supplemental structural calculations for:

talerman-simon residence

**3879 west mercer way
mercero island washington**

**pr- plan review responses
fd- foundations**

**FOUNDATION PLAN**  
1/4" = 1'-0"

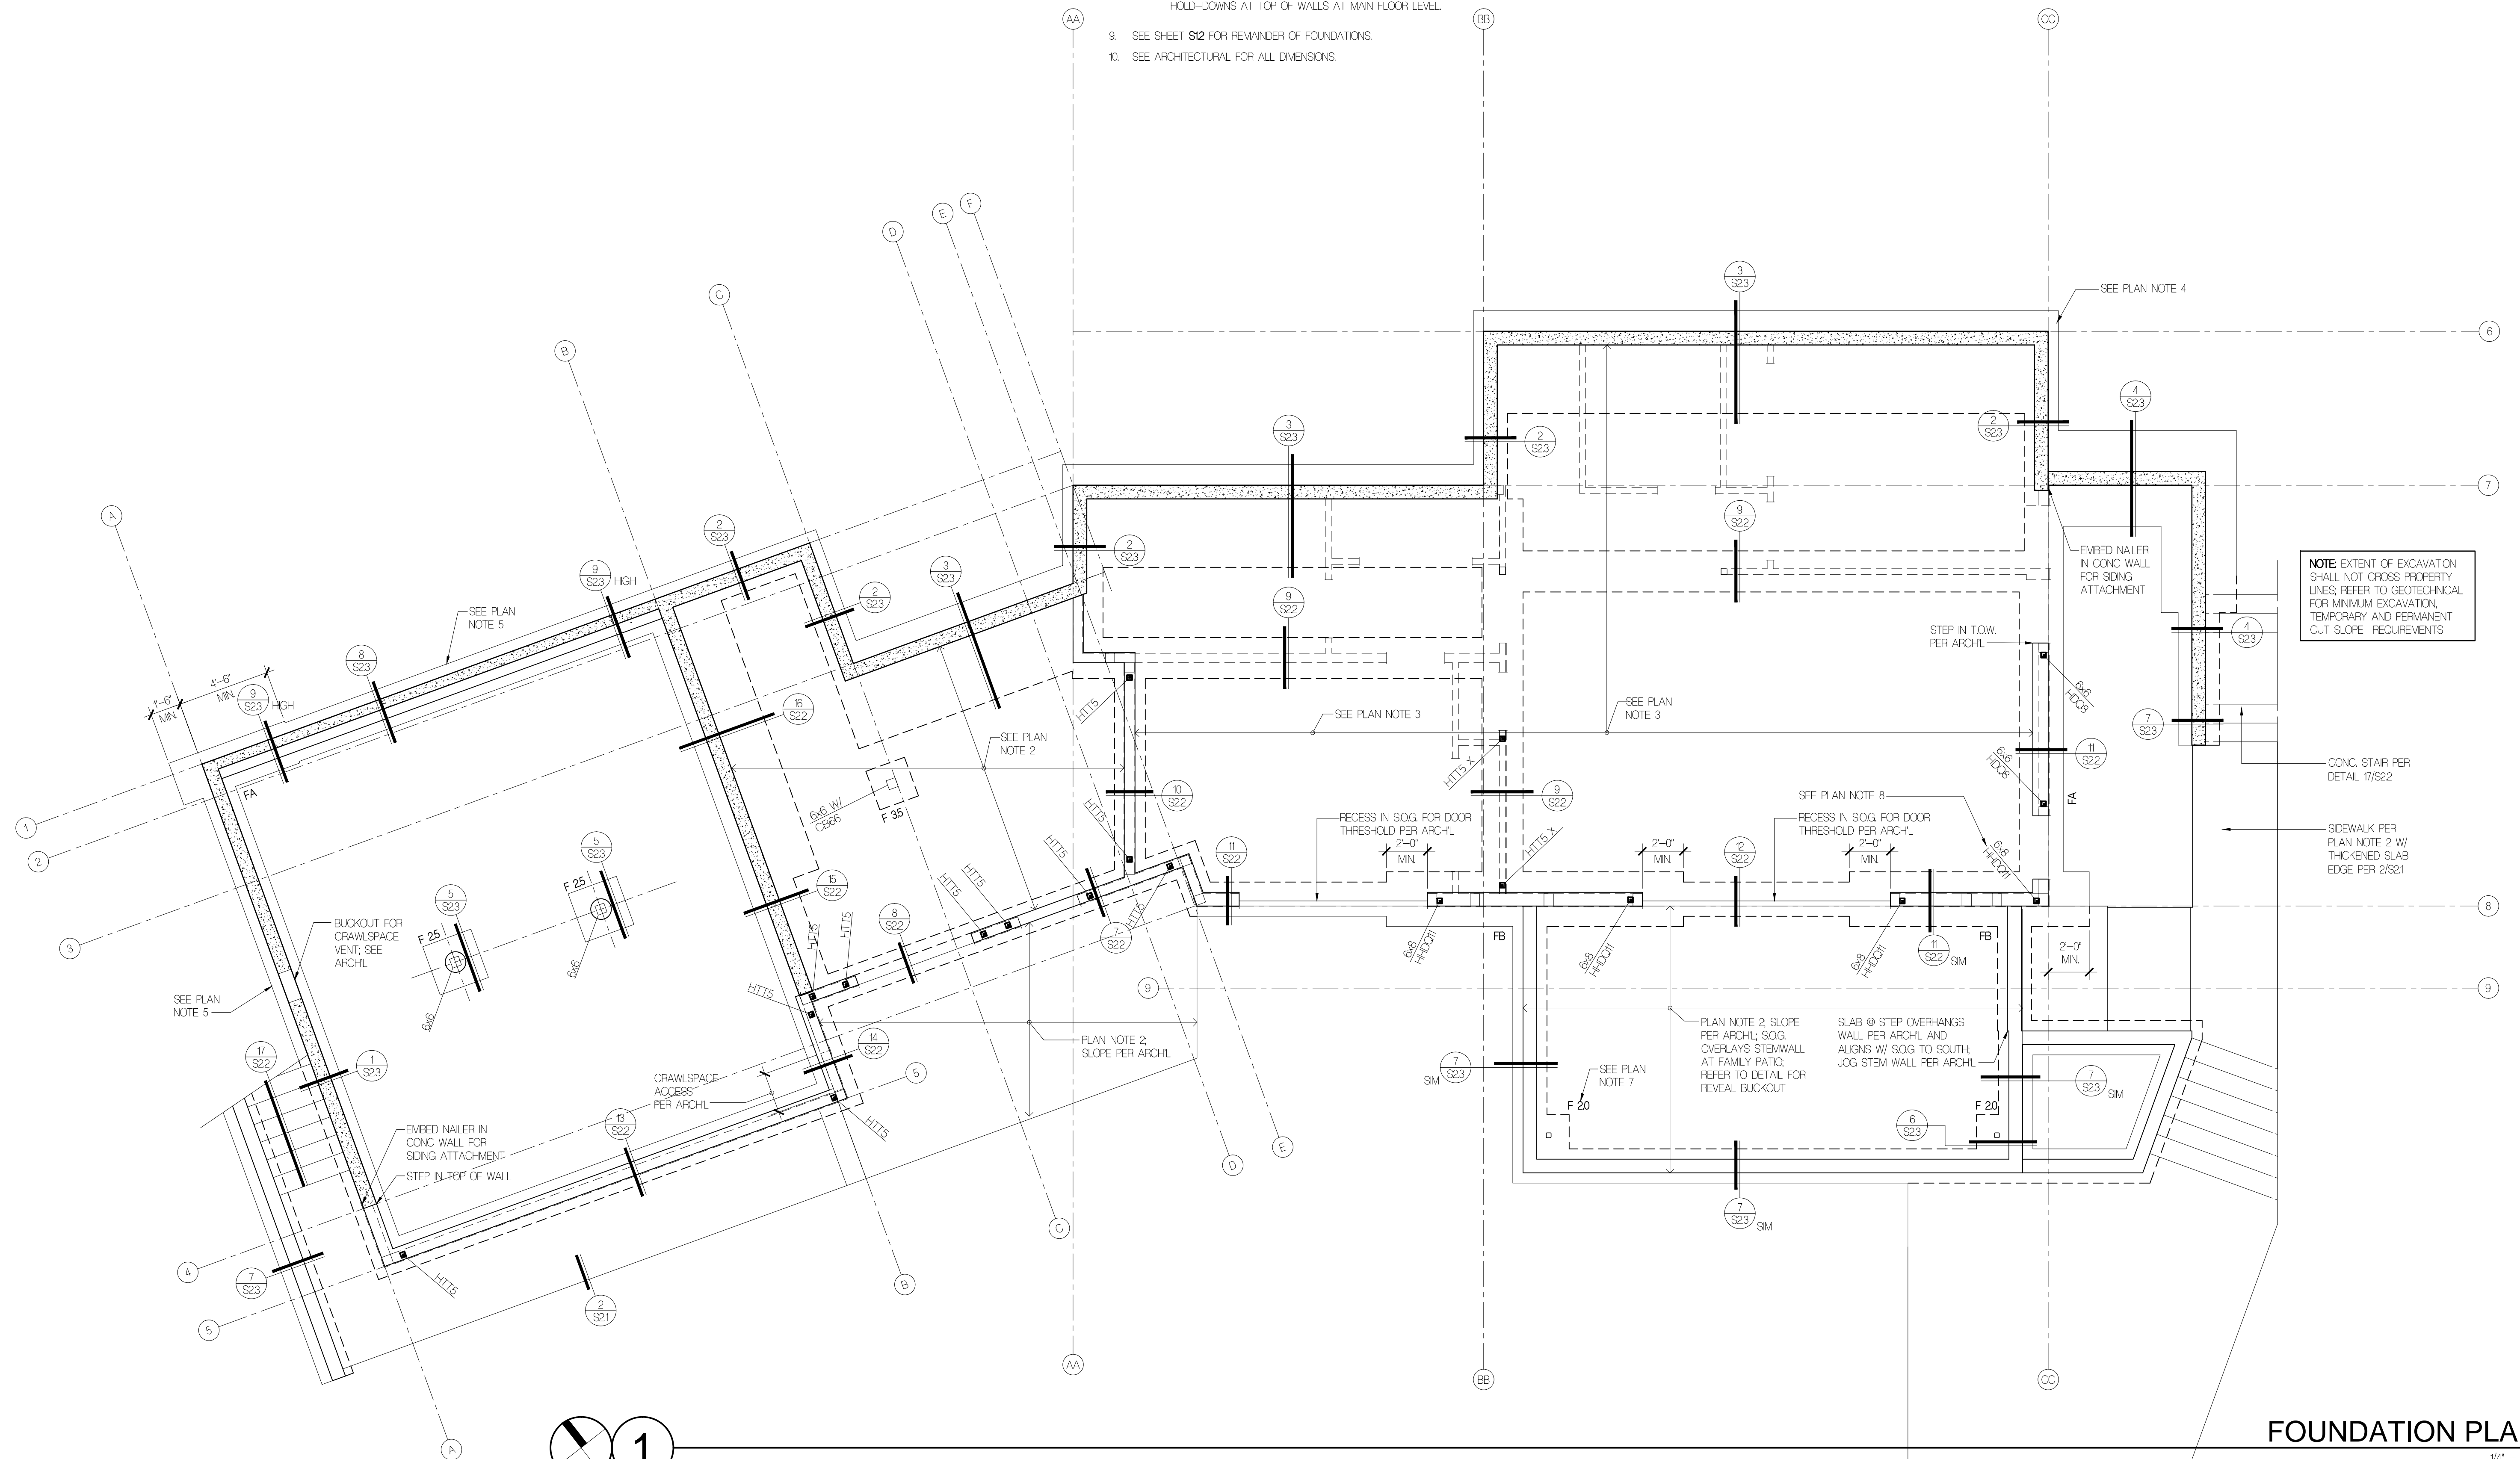
■ IGNORING PASSIVE PRESSURE ON 18" OF EMBED. OF RETAINING WALLS - SEE REUSED RETAINING WALL CALCULATIONS

NOTE: REDESIGN W/ NO PASSIVE PRESSURE EXCEPT: DRNEWAY WALLS (W/NO HEEL) WHERE KEYS ARE USED TO ENGAGE PASSIVE PRESSURE

W2 WALLS SPANNING HORIZONTALLY
REACTION INTO PERPENDICULAR WALL @
EACH END - CHECK FRICTION RESISTANCE
ON THESE

$$\therefore \text{FRICT. RESISTANCE} = 16.4k. = 2.48 \times P_{MAX} \checkmark$$

# S1.3

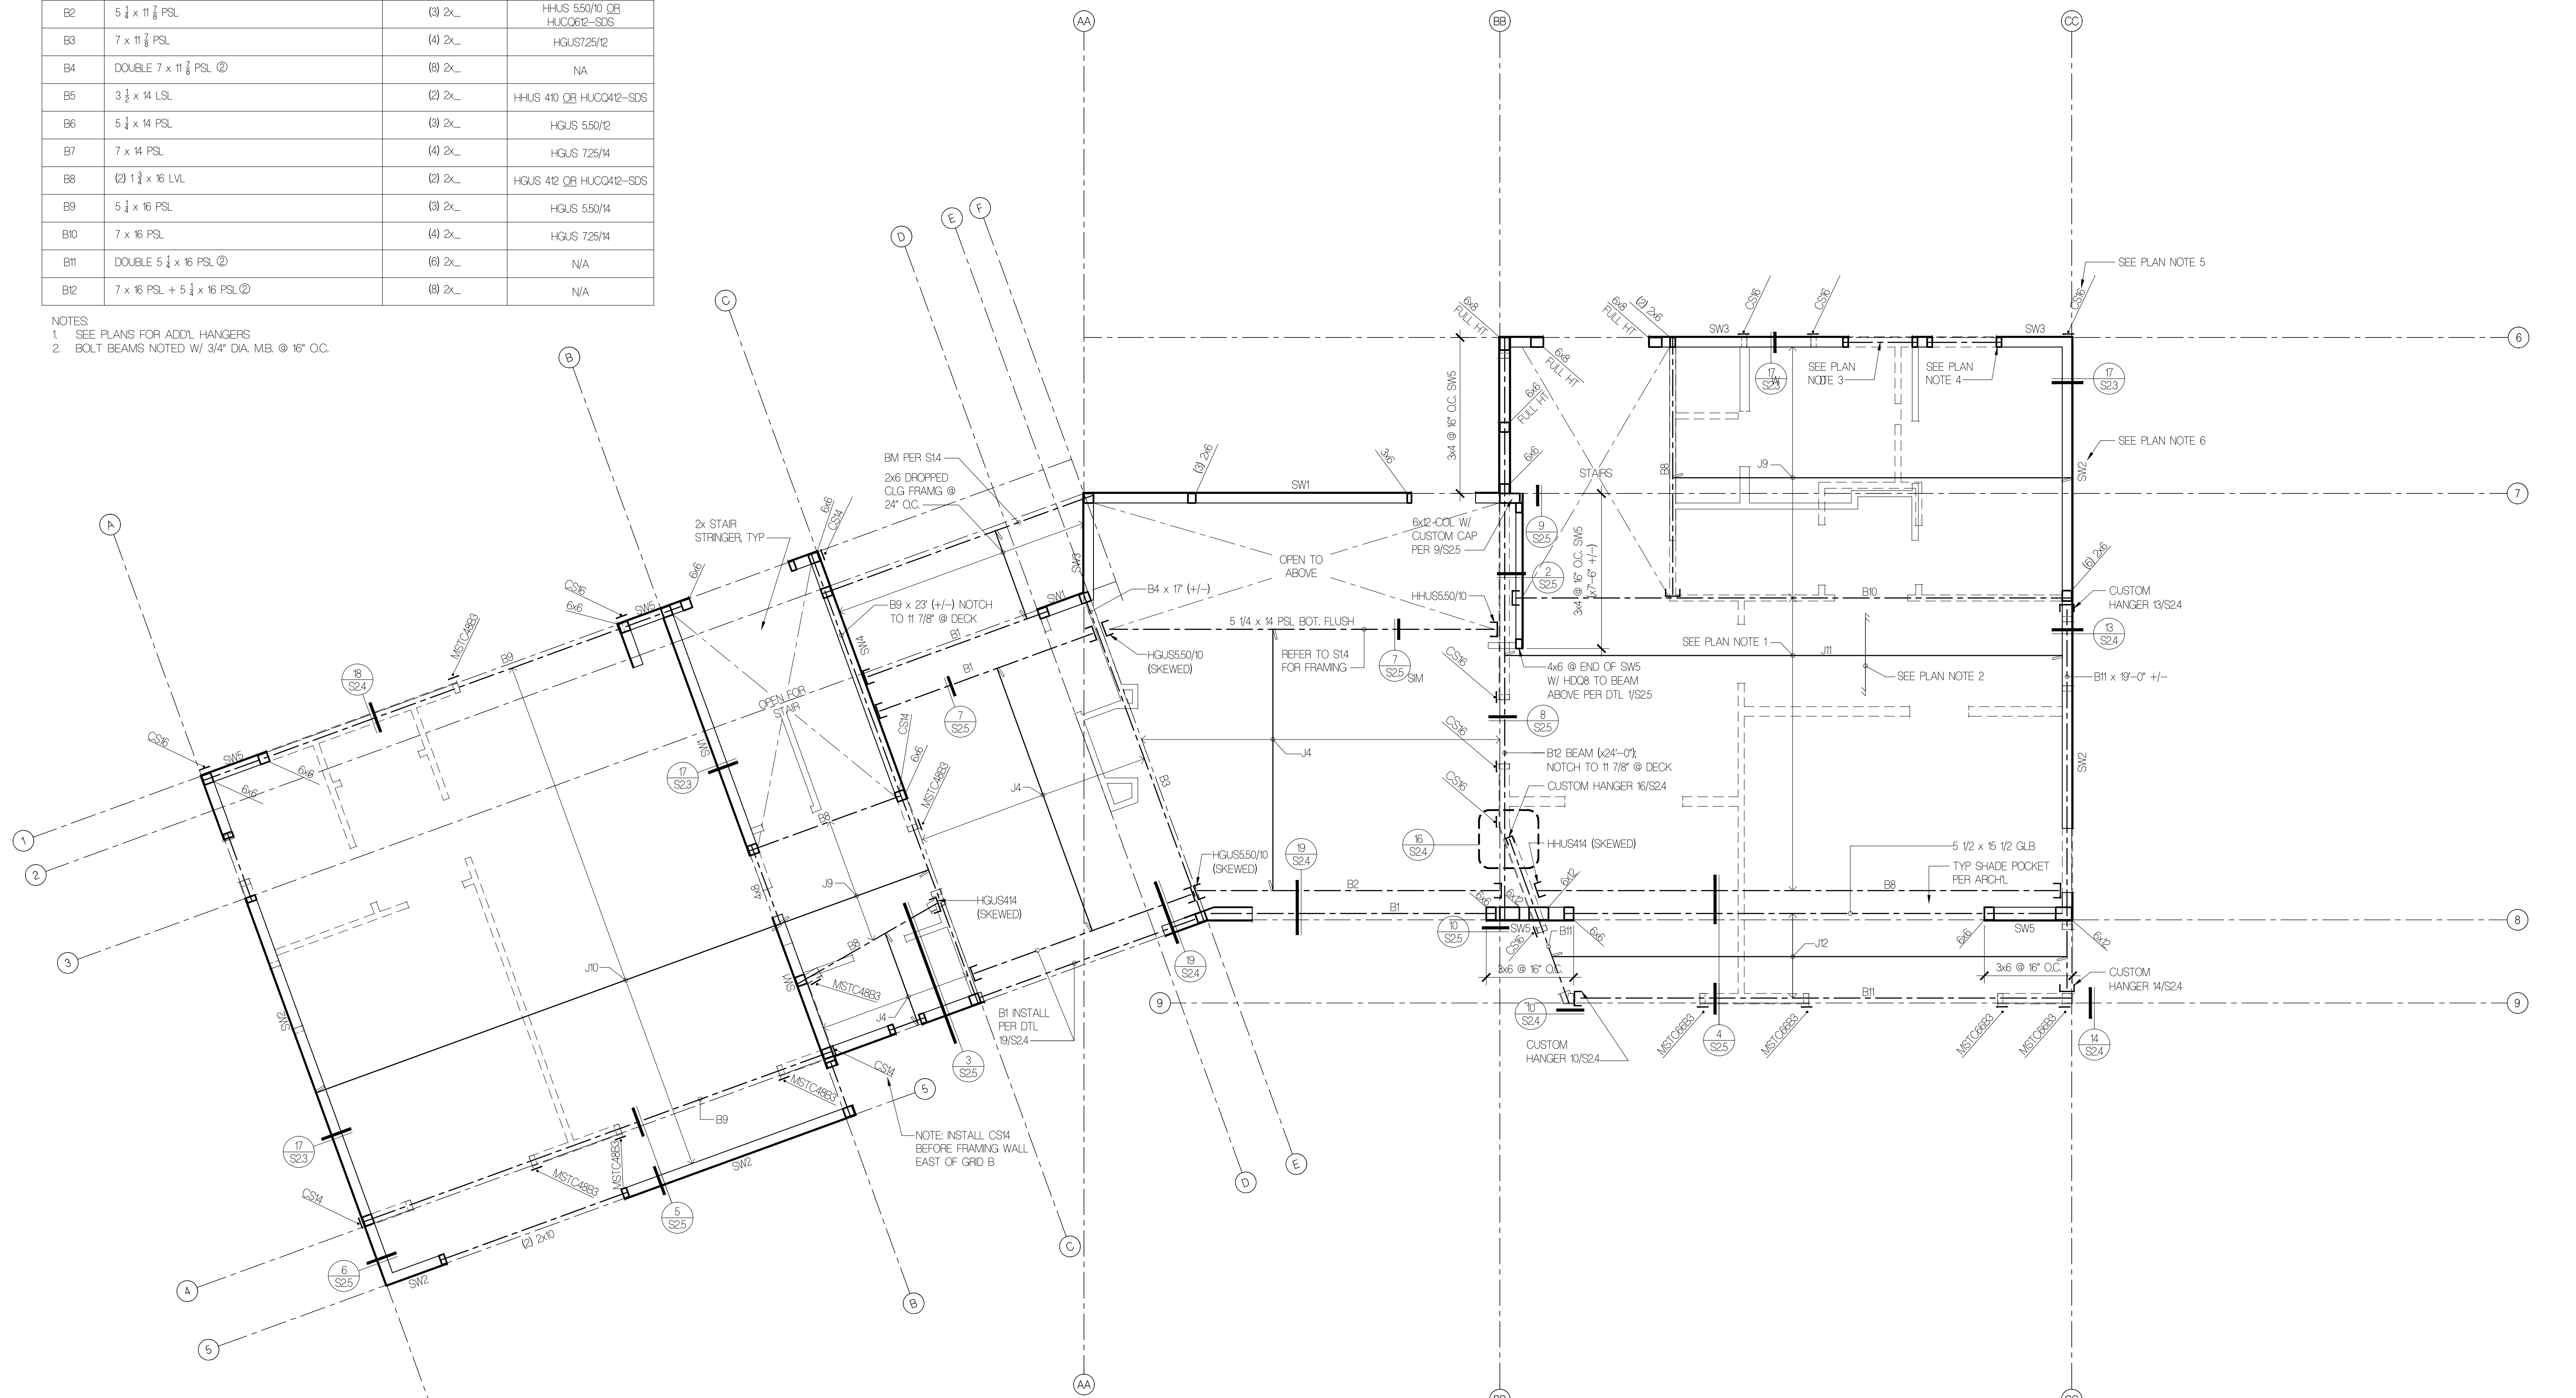
SHEET S1.2
 (& SHEET S1.3)

■ STRAPS AT REENTRANT CORNERS
 FOR SIMPLICITY USE ONE STRAP DESIGNED
 FOR WORST CASE

SHEET S1.3

■ SHEAR WALL W/ DISCONTINUOUS HOLD-DOWNS (CS16s)
 SW3 WALL

CMSTC16 4585 # CAPACITY [MAX SUB. DIAPH
 LOAD CONN LESS
 THAN 3,000#]
 NAILING TO FLUSH BEAM

(2) 16d SINKERS
 (2) ROWS @ 4 1/2" o.c. 6'-4" (MIN.)

EXTEND 1/3 RD DIAPH DEPTH / BURL.
 (2) ROWS @ 3" o.c.

■ CHECK WALL FOR LOAD CASE 7. (WORST CASE) (0.6 FL)

SW3 OK

NO ADDITIONAL SHEAR FROM
NON-CONT HOLD-DOWNS - PER WOOD
BEAM NEURAL ENGINEER BECAUSE
IT BEARS ON CONC. FDN.
T = C (TOP/BOT PLATES) = 624# ✓
